Subject: EIS - First Building Bradfield City Centre (SSD-25452459) (Liverpool City)

Attachment A – EES Waterway health comments for the First Building Bradfield City Centre (SSD-25452459)

Comments are specific to Section 3 – Stormwater Management of the Bradfield Civil Design Report and the relevant Civil Engineering Plans provided at Appendix D of the EIS.

EROSION AND SEDIMENT  
CONTROL PLAN

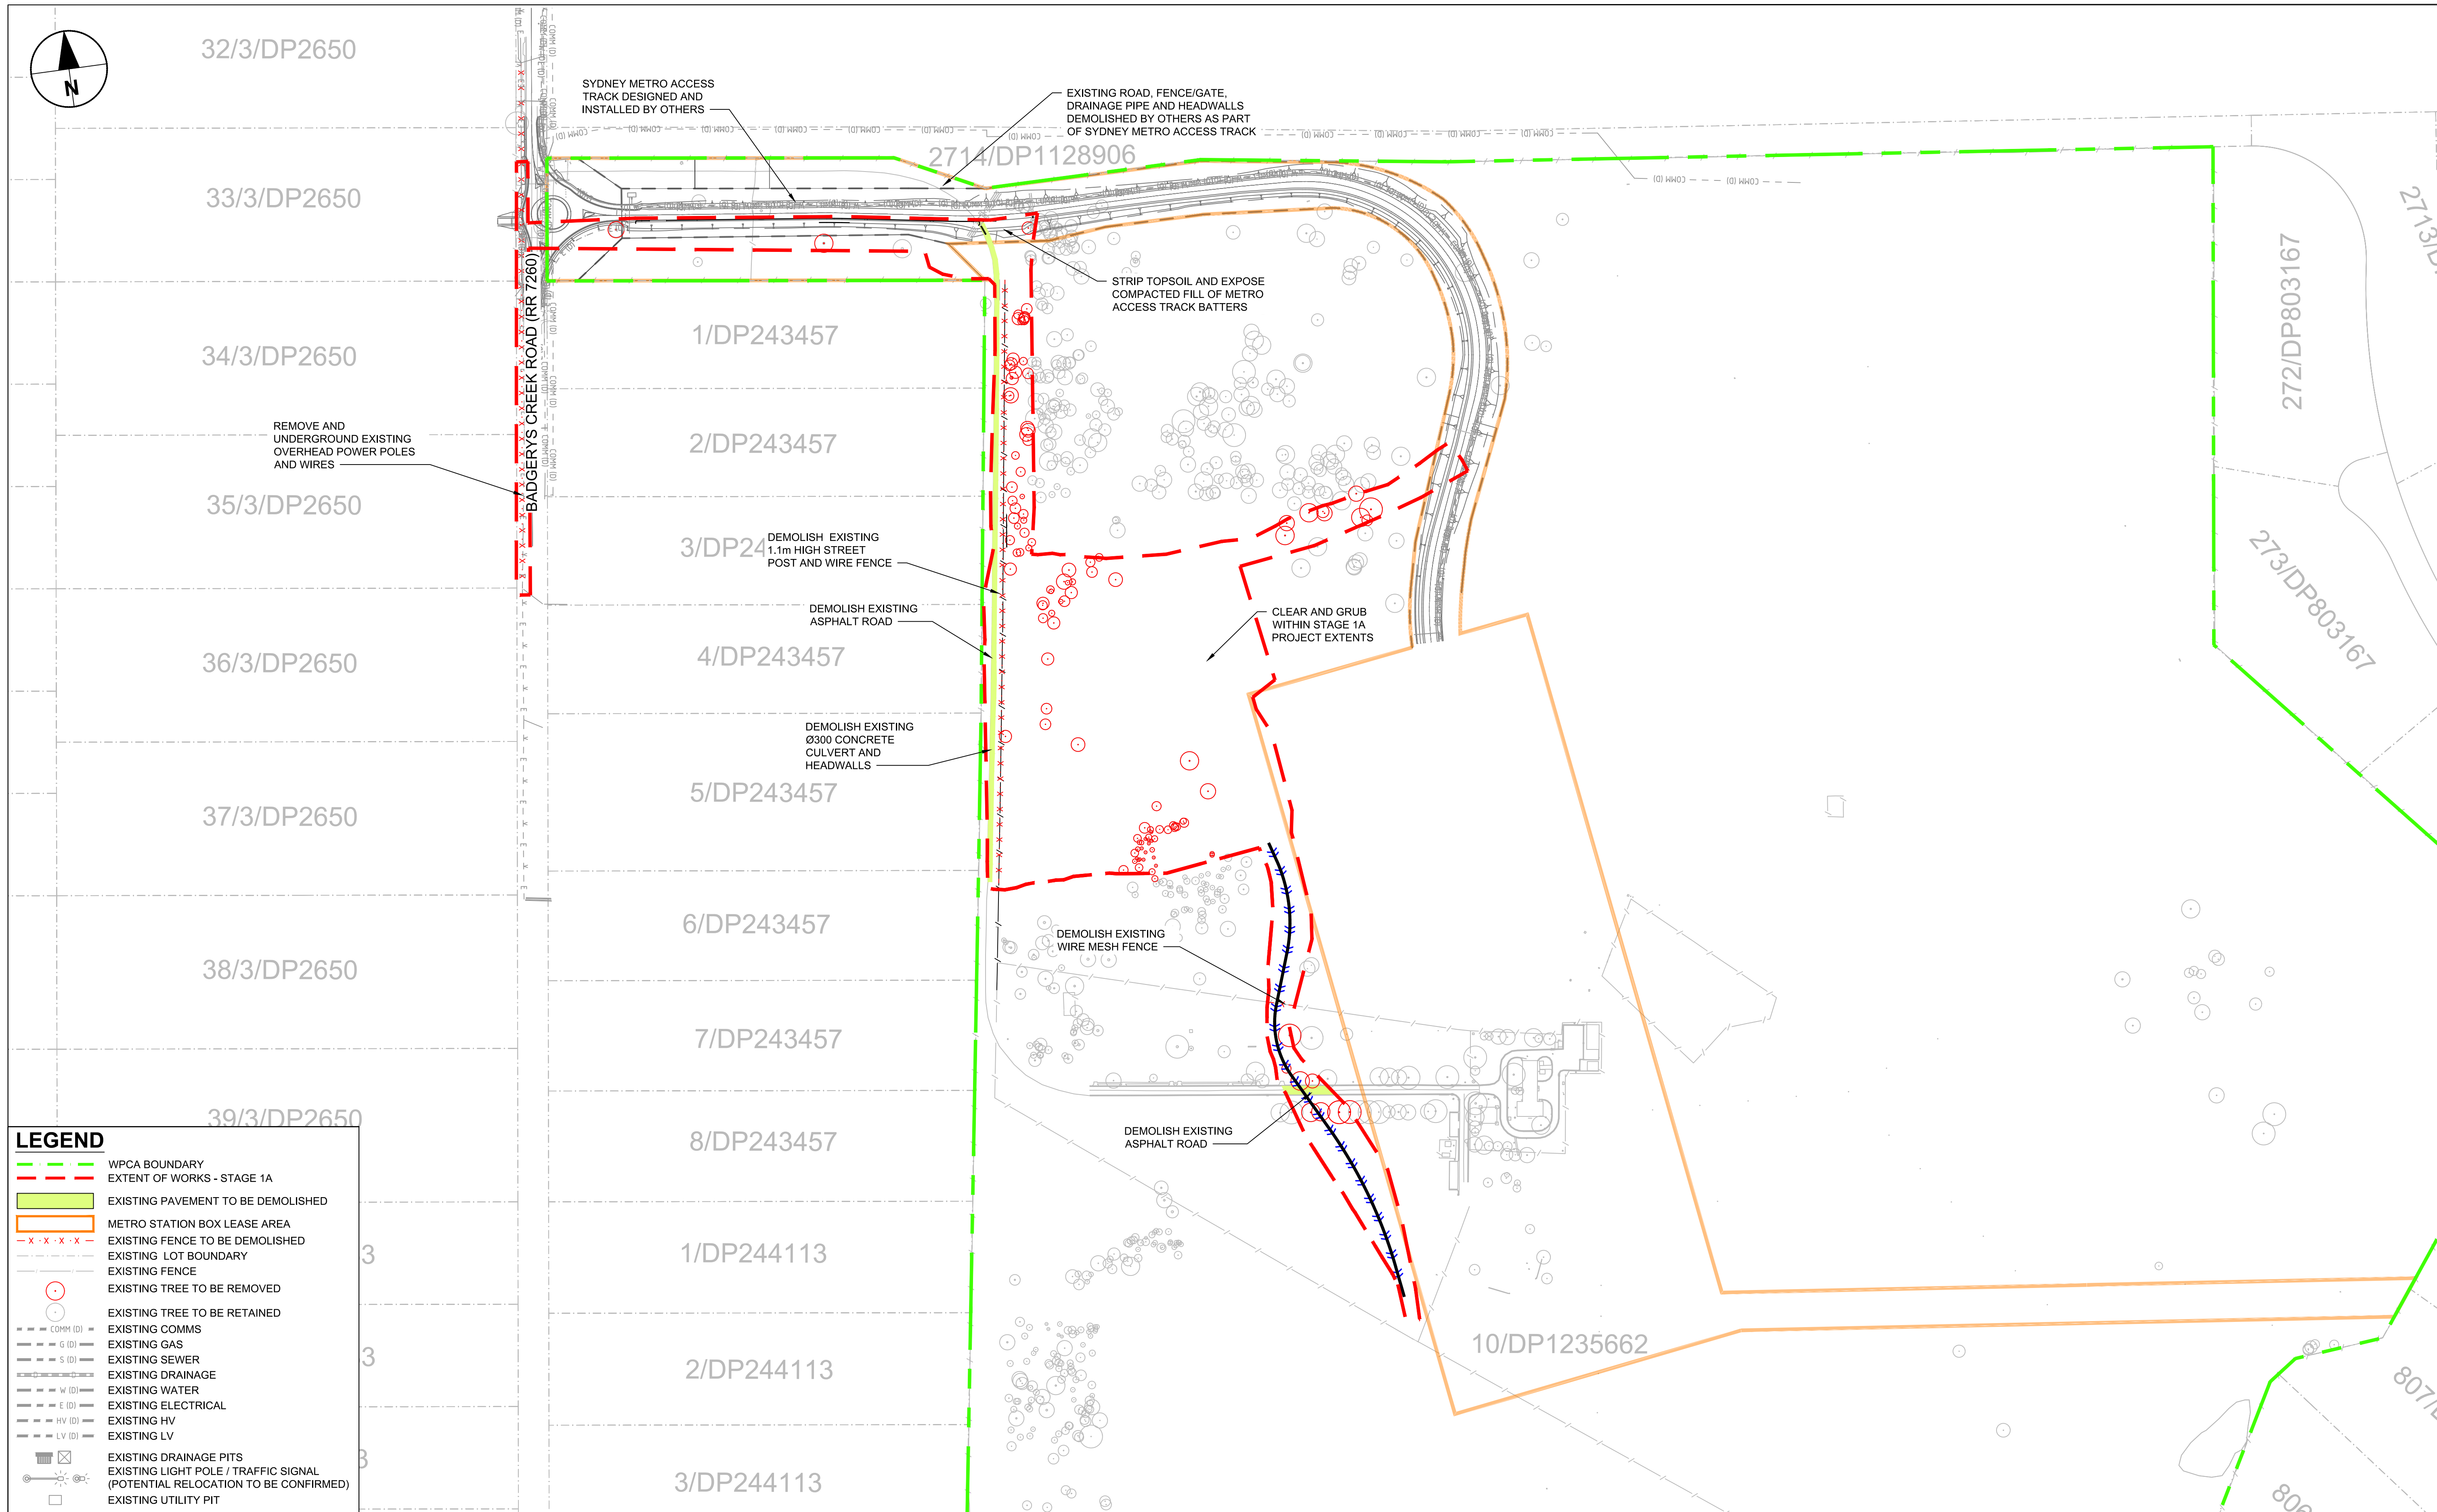
EES recommends that the Erosion and Sediment Control Plan for the site should include the construction phase stormwater quality targets specified in the toolkit, and now publicly available in the draft Western Sydney Aerotropolis DCP.
